**RE: RIBBON DEVELOPMENT SSD-5397 – CLARIFICATION OF RESPONSE TO SUBMISSIONS**

Kass-Hermes have been engaged by Anson City Developments Pty Ltd (Anson), which has a majority interest in the Emporio Building at 339 Sussex St Sydney, to act on their behalf in relation to the above development.

Massing Study 1

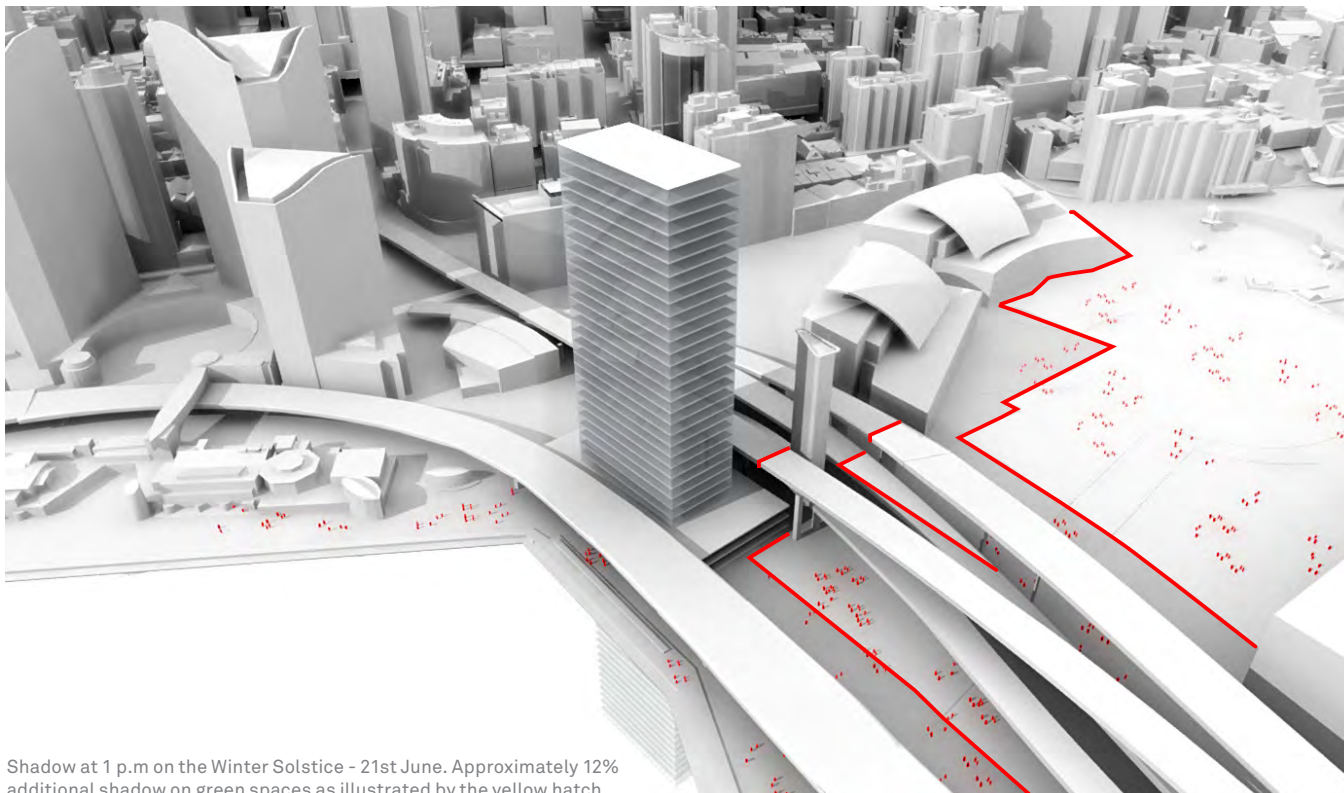
It is significant that in reviewing design options, the EIS for the proposal states that Option 3 (building a tall single tower on a large footprint) would create issues of pedestrian connections and movements to public domain areas as well as significant overshadowing to the public domain areas.

Massing Study 3

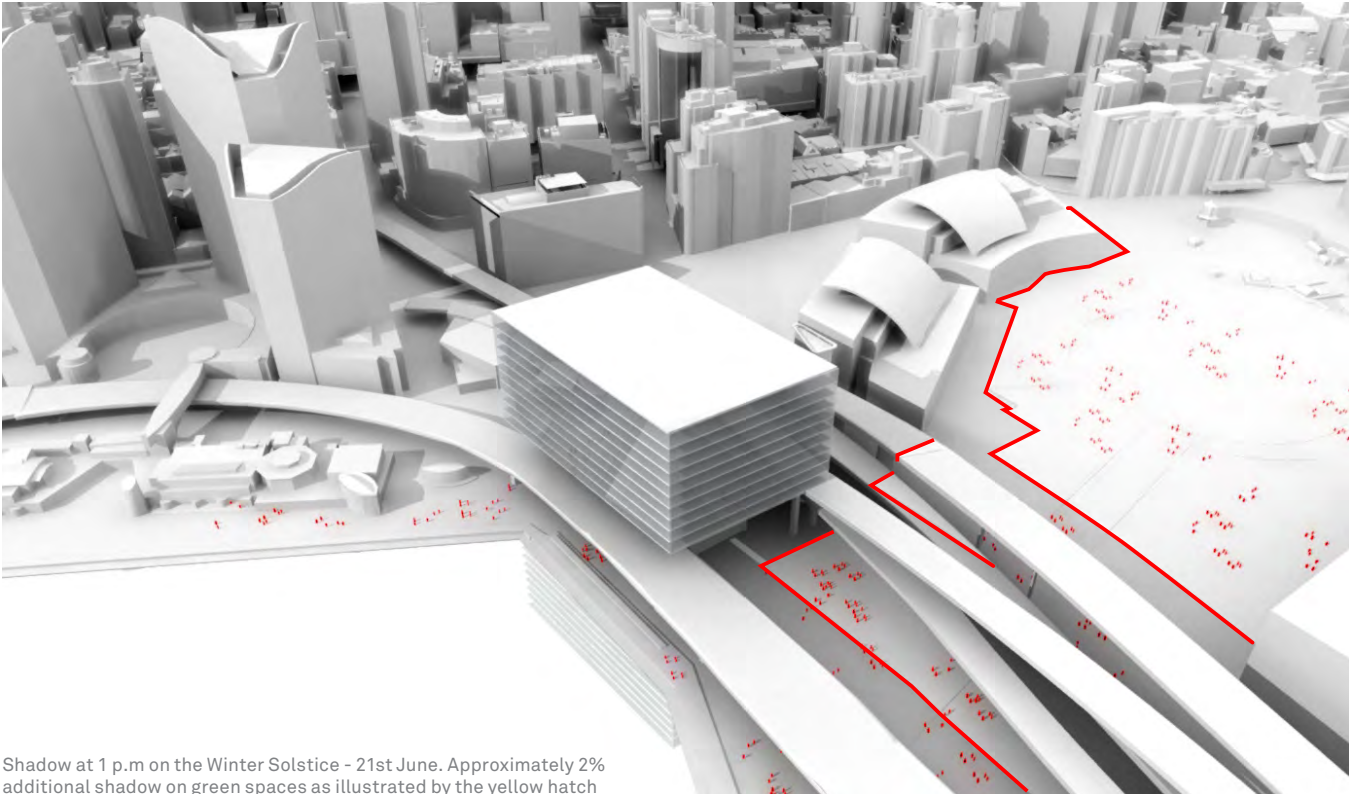
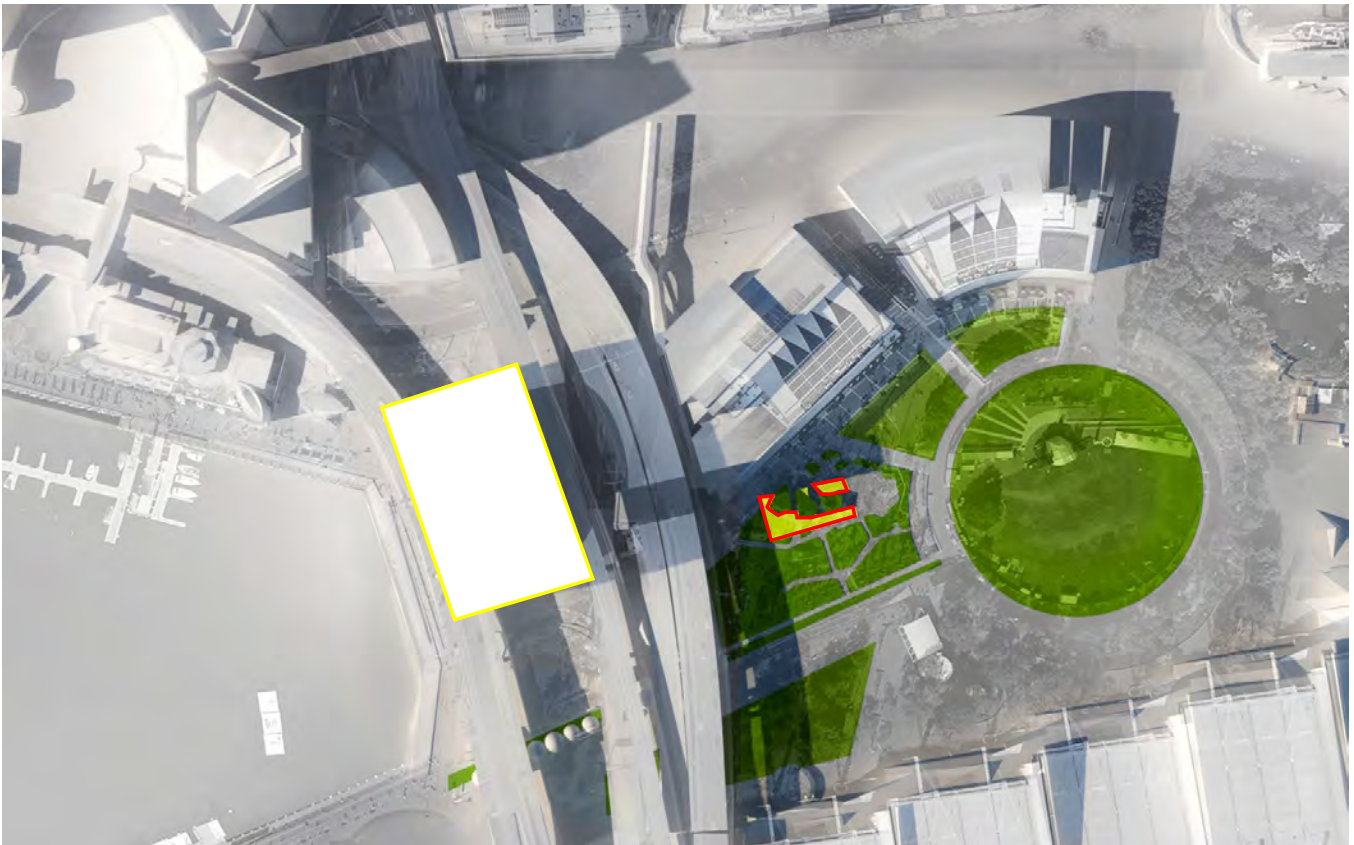
Option 5 (building partly over the expressway) was perceived as top-heavy as well as creating significant overshadowing over the public domain. Option 4 (Two thin Towers) had similar overshadowing issues.

Massing Study 4

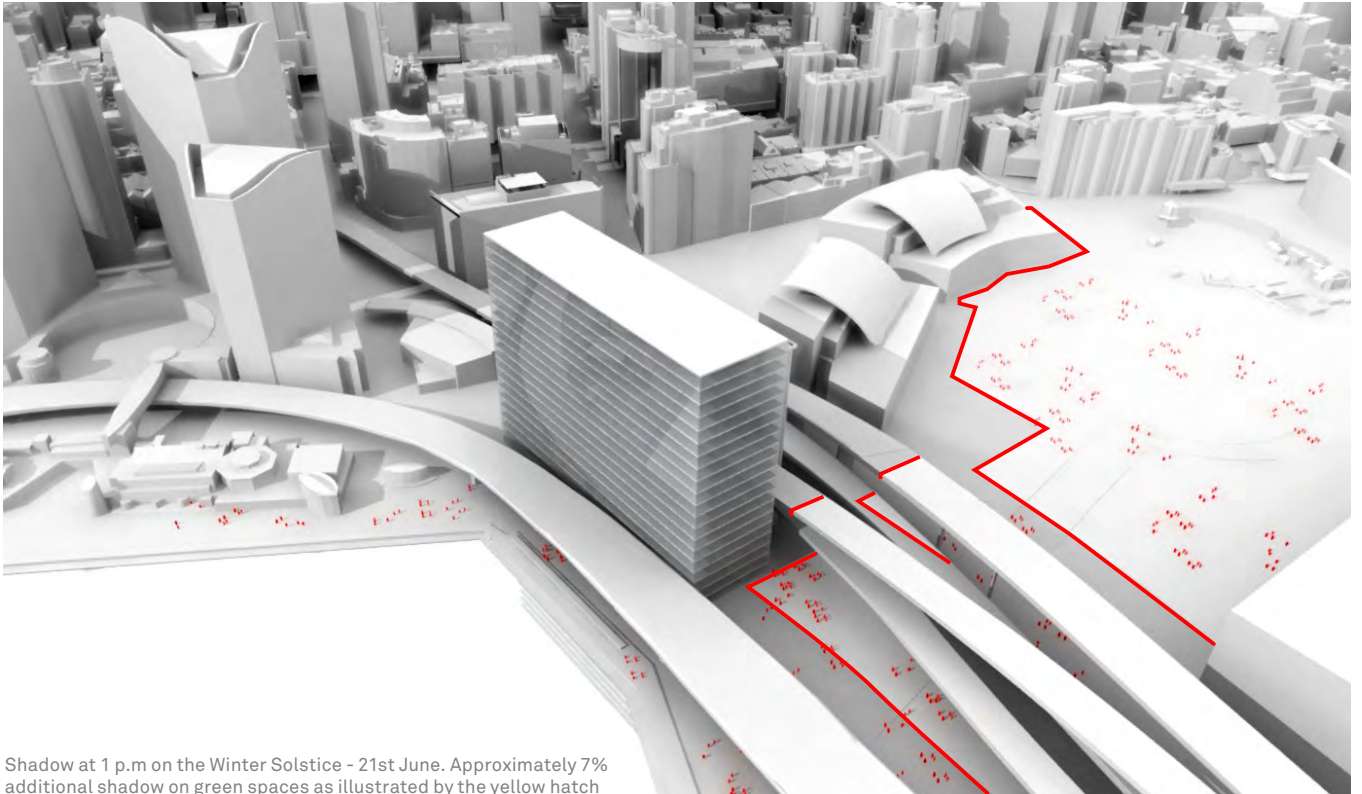
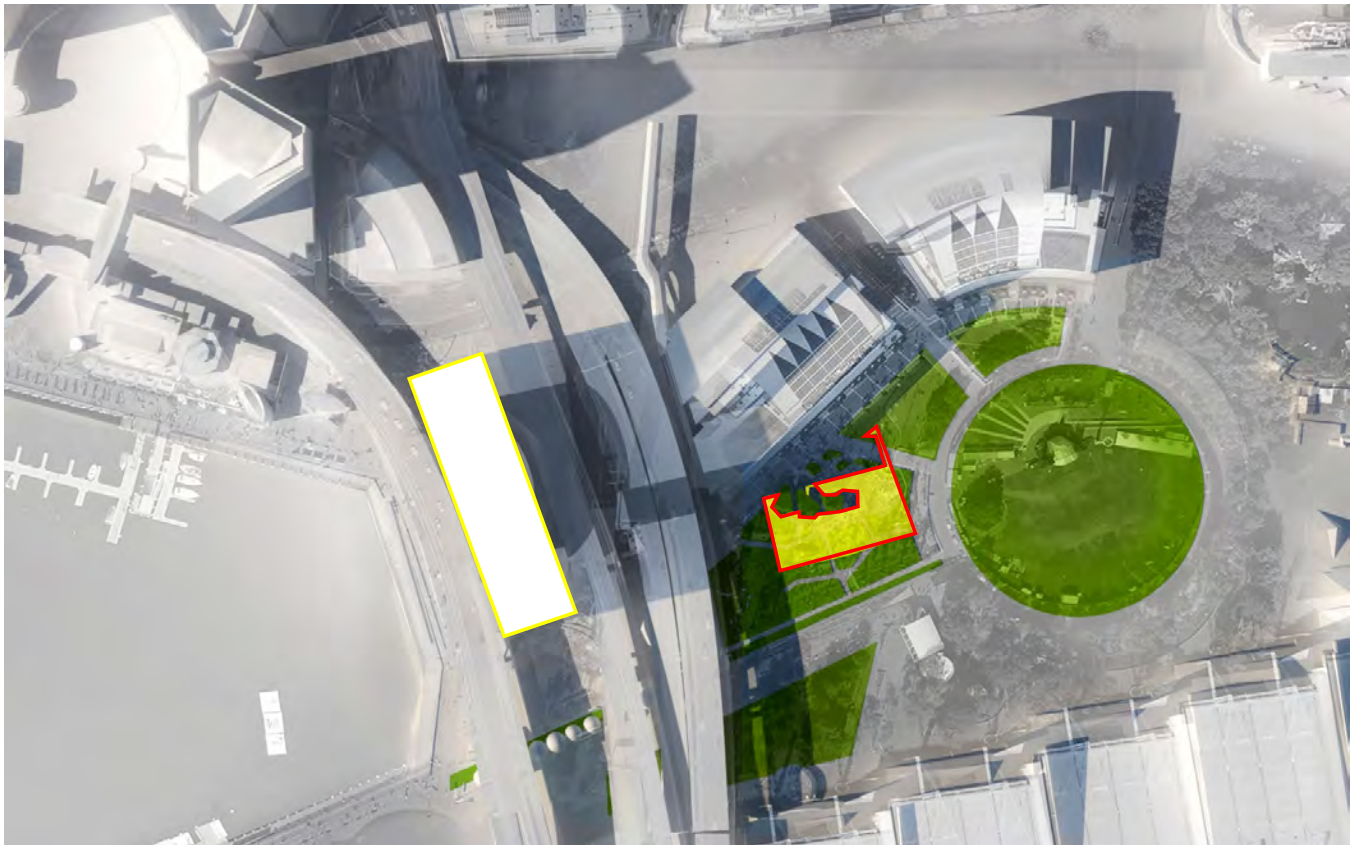
Option 6 (a thinner mass with height comparable to neighbouring buildings) was perceived as more pleasing visual outcome but resulted in overshadowing of the children's playground; even though children's playgrounds are generally now provided with shading structures as preventative measure against skin cancer.
